From: Laura Gibbons <Laura.Gibbons@arun.gov.uk>
Sent: 05 April 2022 11:57
To: Planning.Responses <Planning.Responses@arun.gov.uk>
Cc: David Easton <David.Easton@arun.gov.uk>
Subject: RE: Planning Consultation on: Y/127/21/RES

Engineers Comments Regarding Surface Water Drainage

Application No: Y/127/21/RES
Registered: 10th September 2021
Site Address: Land at Bilsham Road Yapton
Grid Reference: 497588 102751
Category: Plan Applicat'n
Description of Works: Approval of reserved matters (appearance, landscaping, layout and scale) following the grant of Y/91/17/OUT for 250 No dwellings with associated parking, road/footway/cycleway provision, open space, landscaping, surface water attenuation & ancillary works (resubmission following Y/152/20/RES). This site is not CIL Liable as in Yapton Strategic Site.

drawing title
Landscape Proposals - Sheet 2

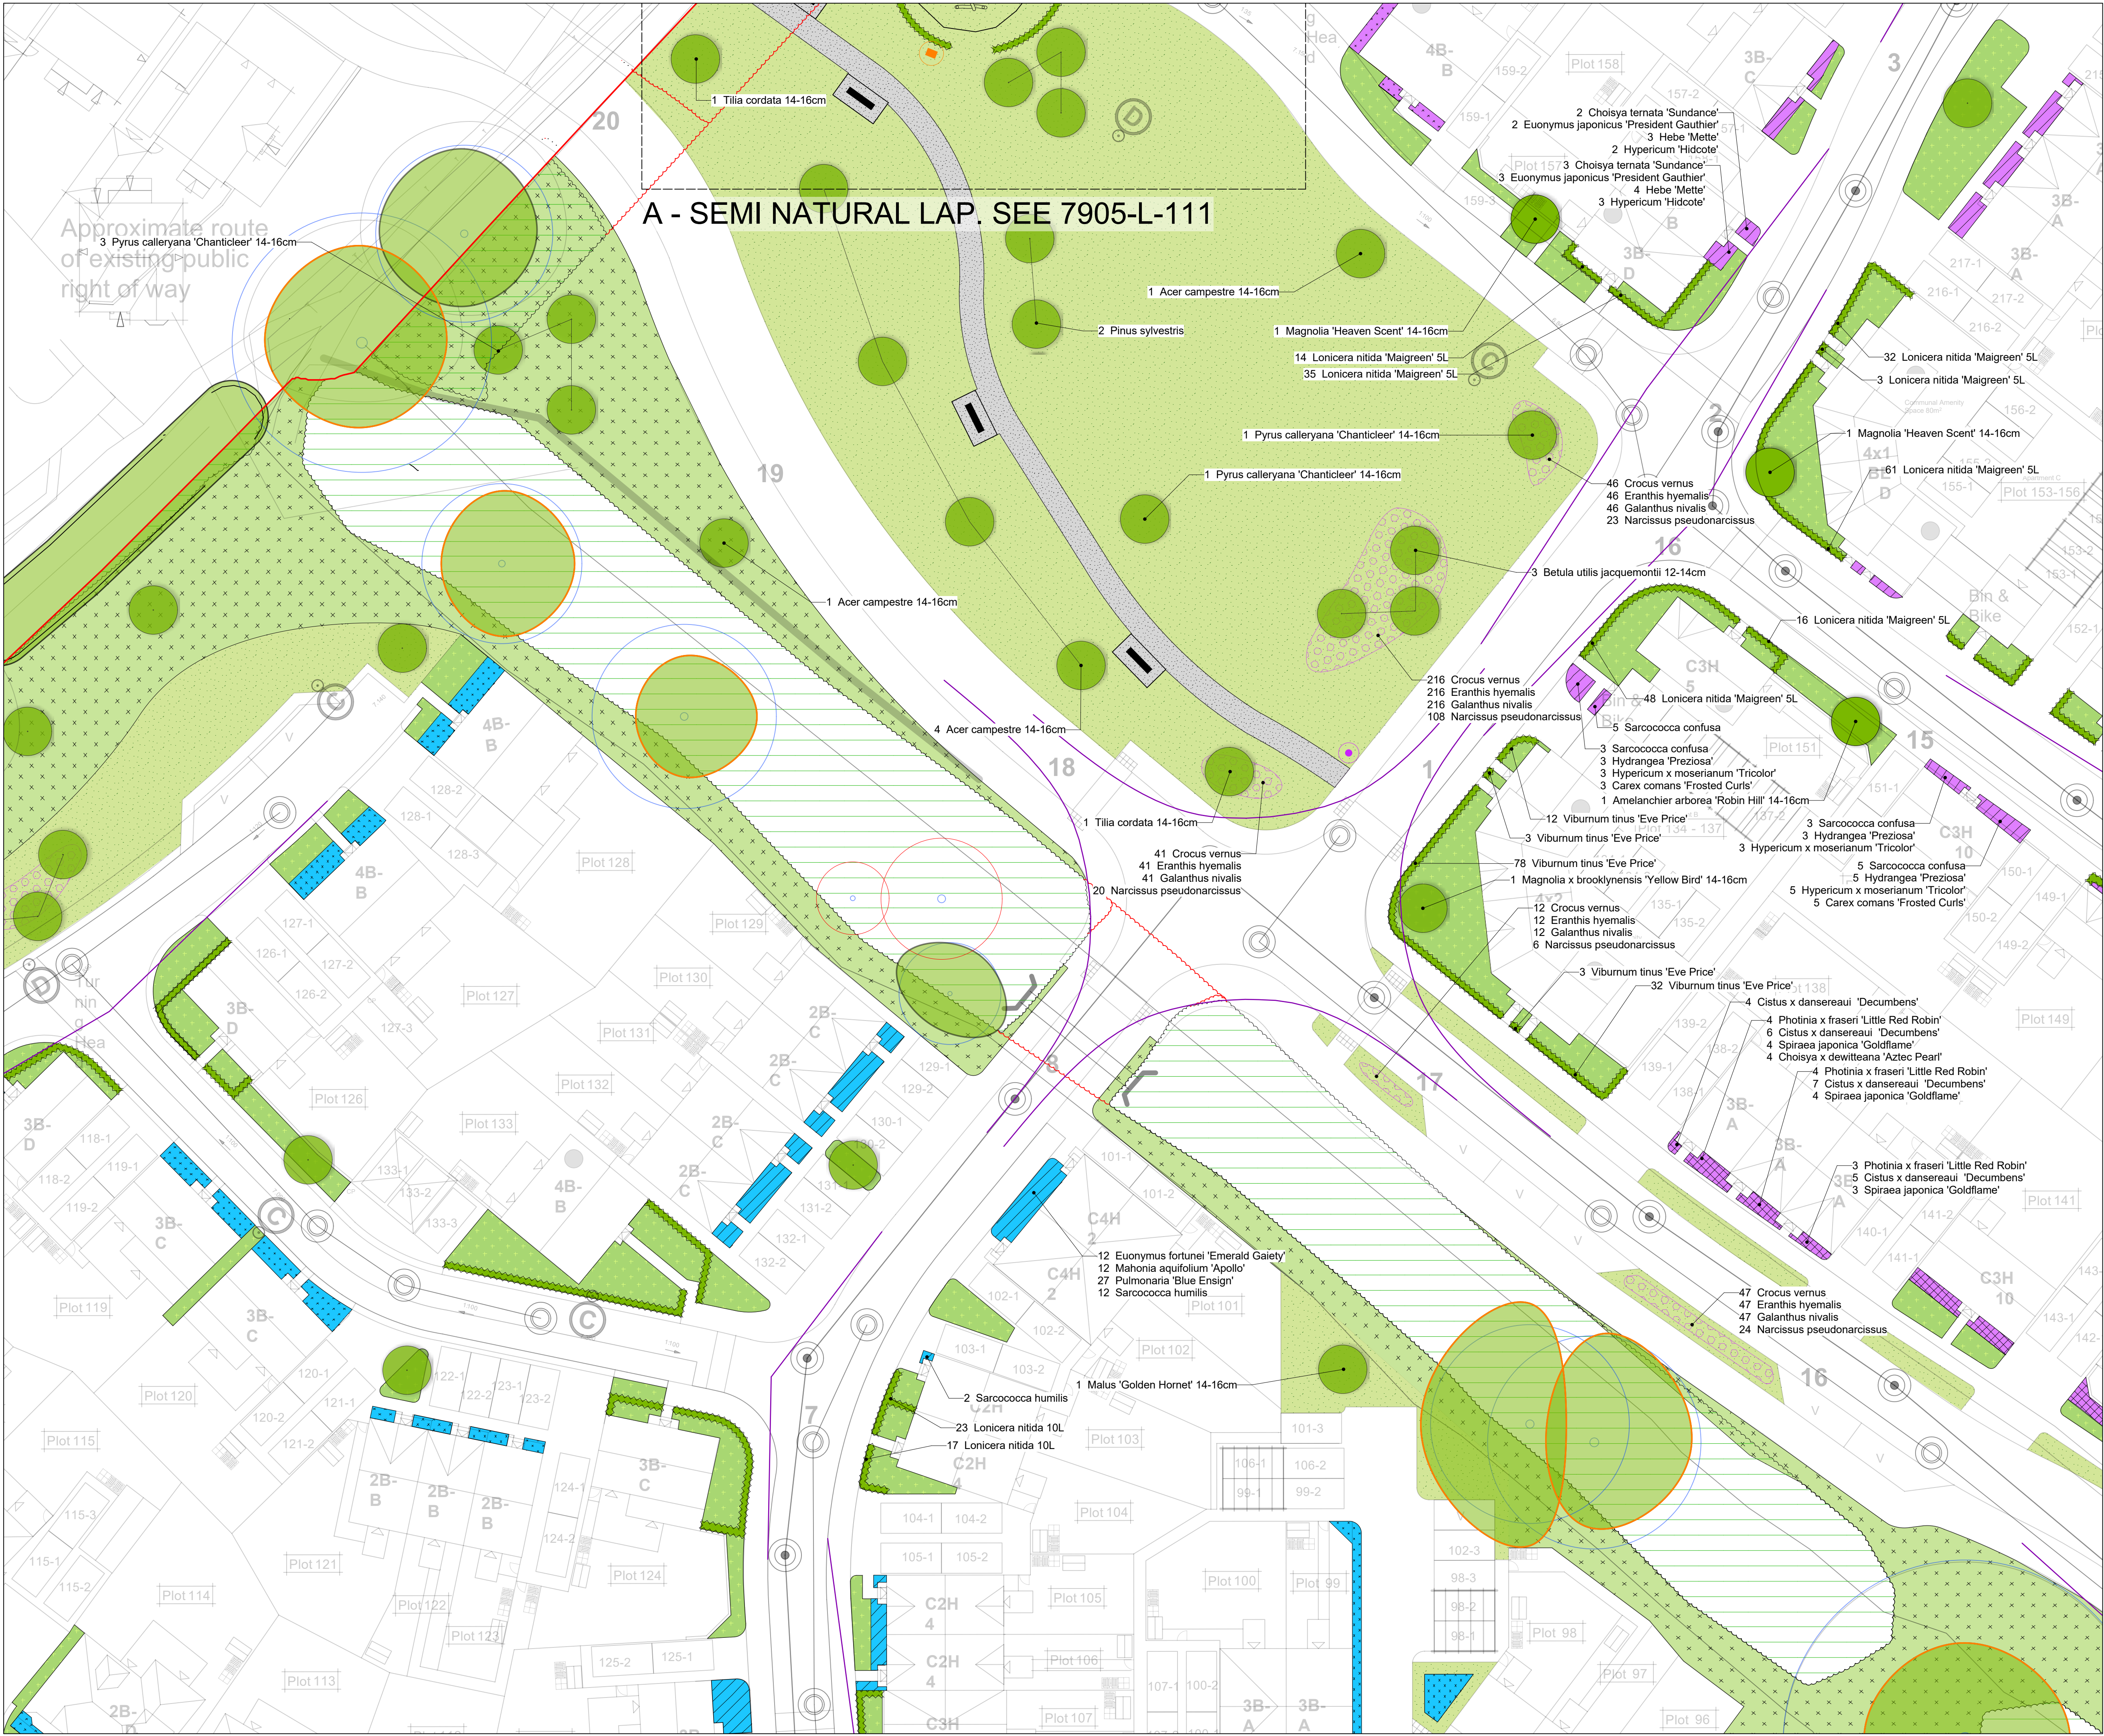
Landscaping proposals showing anticipated root potential areas have been provided. Further details regarding drainage proposals will need to be agreed under a separate DOC application, tree potential areas will need to be reviewed with the applications to discharge drainage conditions.
